Your Ref: OWPC24421
Our Ref: LU/273/19/HH 28-08-2019
Please ask for:
Zac Denton

Single storey rear extension and single storey extension to rear of existing garage.
Windlesham 7 St Winefrides Road Littlehampton

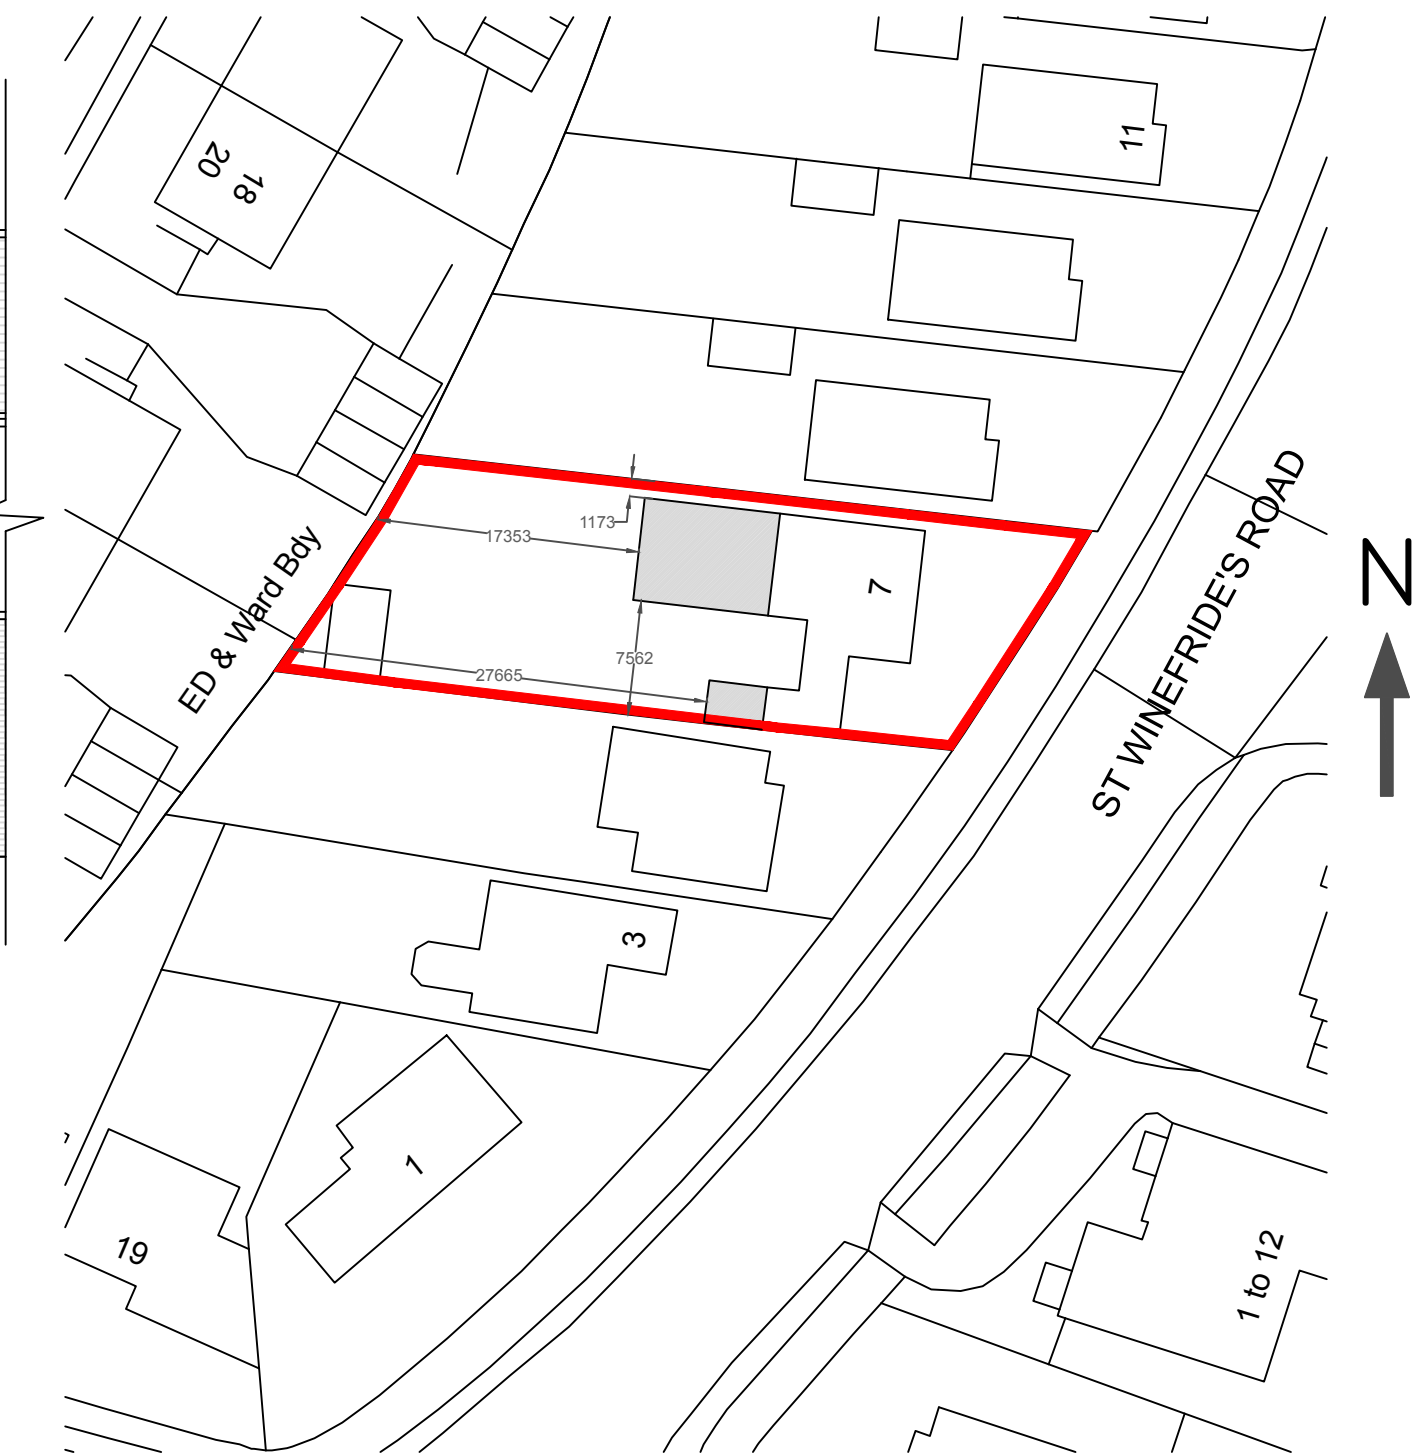
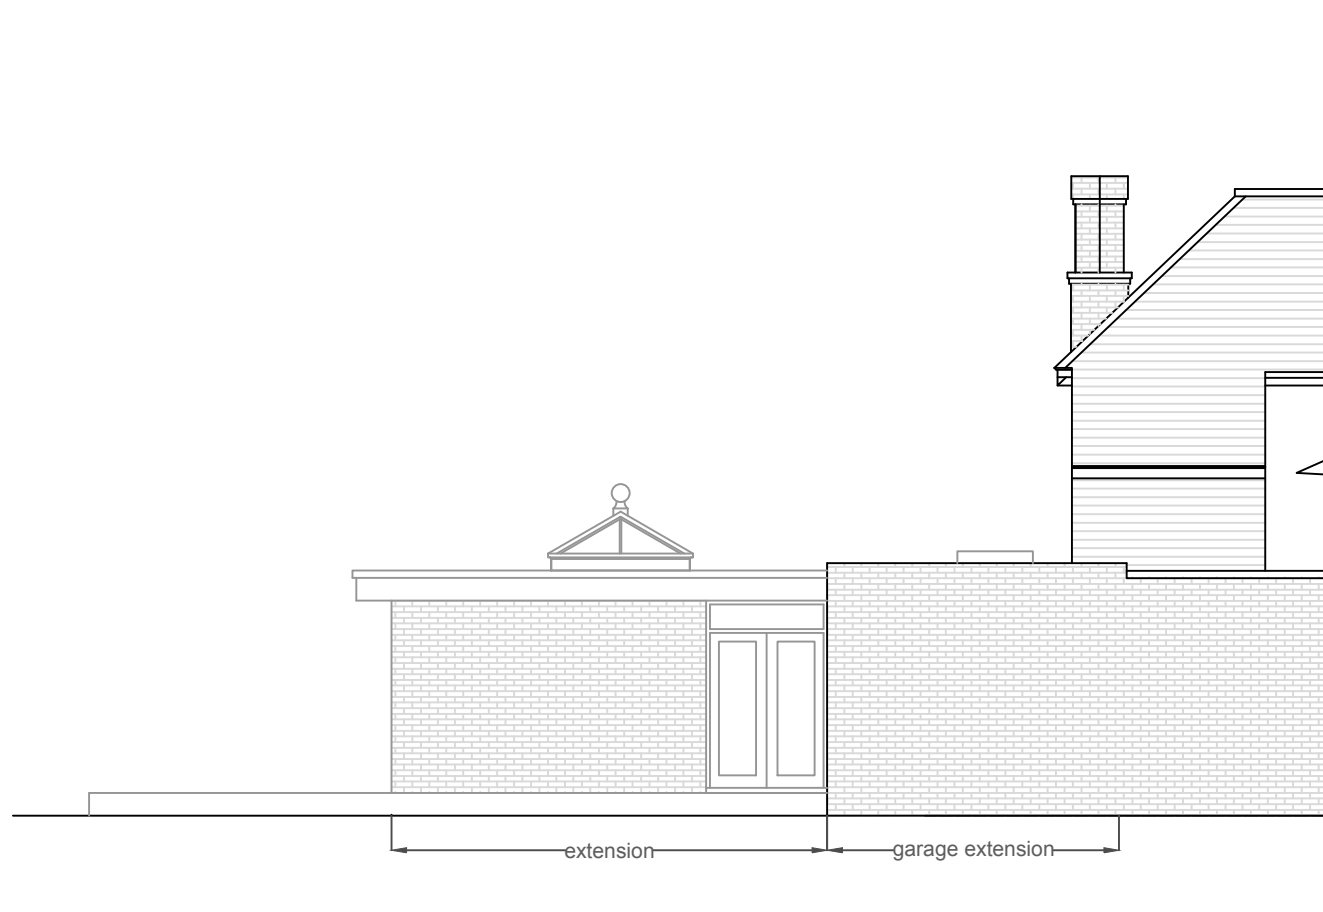
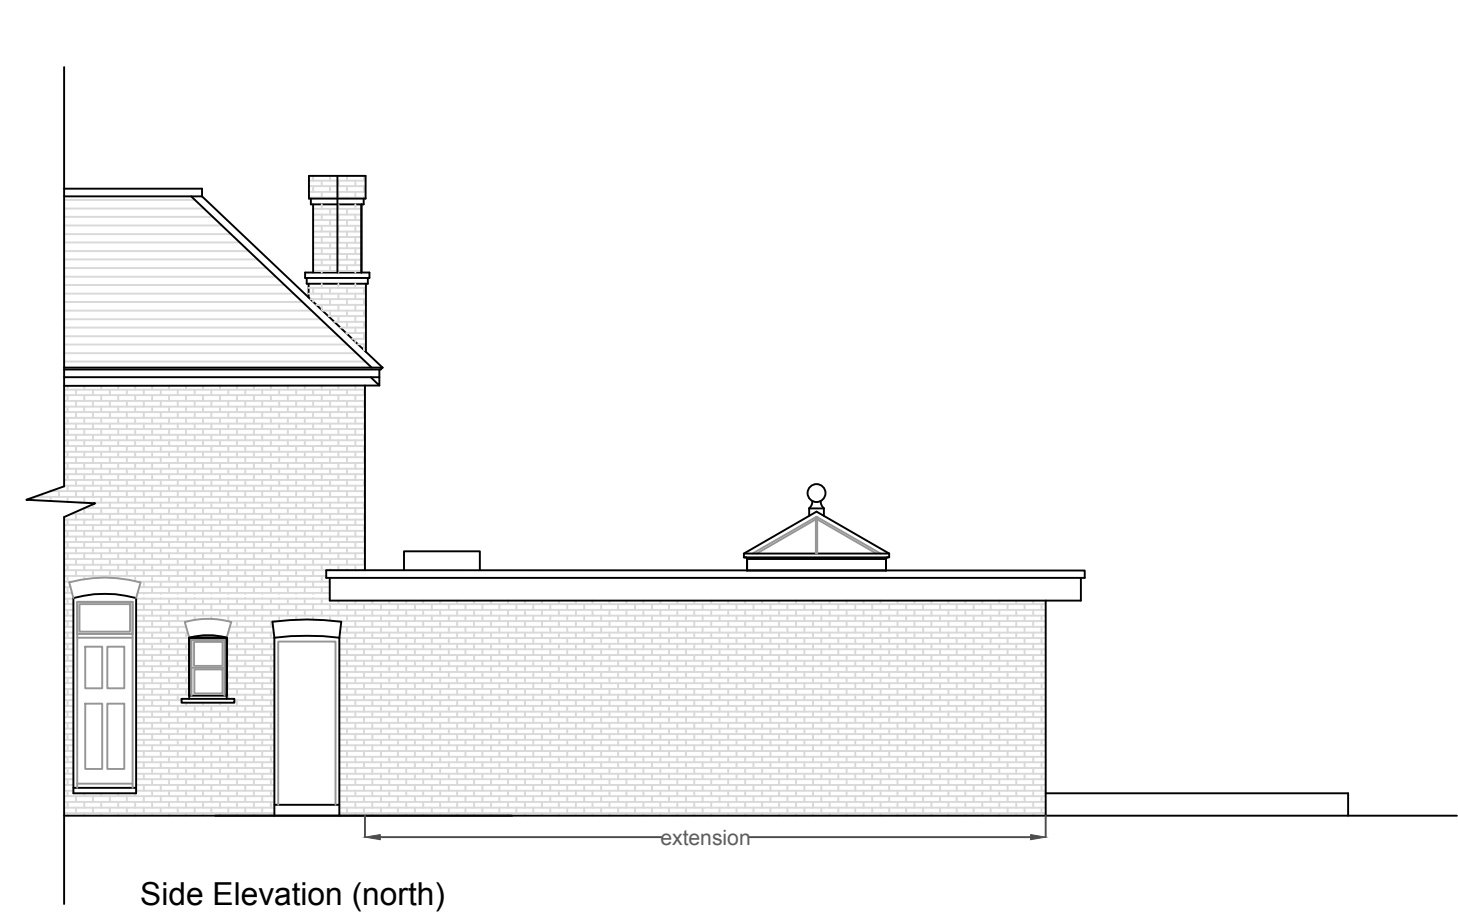
With regard to the planning application at the above property, as direct neighbours, we have some points that we would like to be considered.
We refer to the single storey extension on the north side. We were forewarned of a possible application and consider this proposed design to be a very large footprint. We wish to oppose this application for the following reasons.
The height (approaching 3.5m) of this building will cause shadow to our garden and loss of light to the rear of our property, except when the sun is at its highest point.
The length of the extension (9m) means that there will be a brick wall for almost half the length of our garden. The length is far beyond the building line of our garage.
The height and length together, mean that we will be looking at a large brick wall. This will be difficult to screen due to the height.
The far end of the extension will be affected by/affect the roots of the mature beech tree near to the fence on our side.

As this extension has a flat roof, it will not give an attractive outlook from the kitchen and upstairs of our property. Many mature small trees shrubs will be lost.
We hope you will take these points for discussion about the above application and we invite you to visit, to look at the proposed site to see it from the angle of our property.
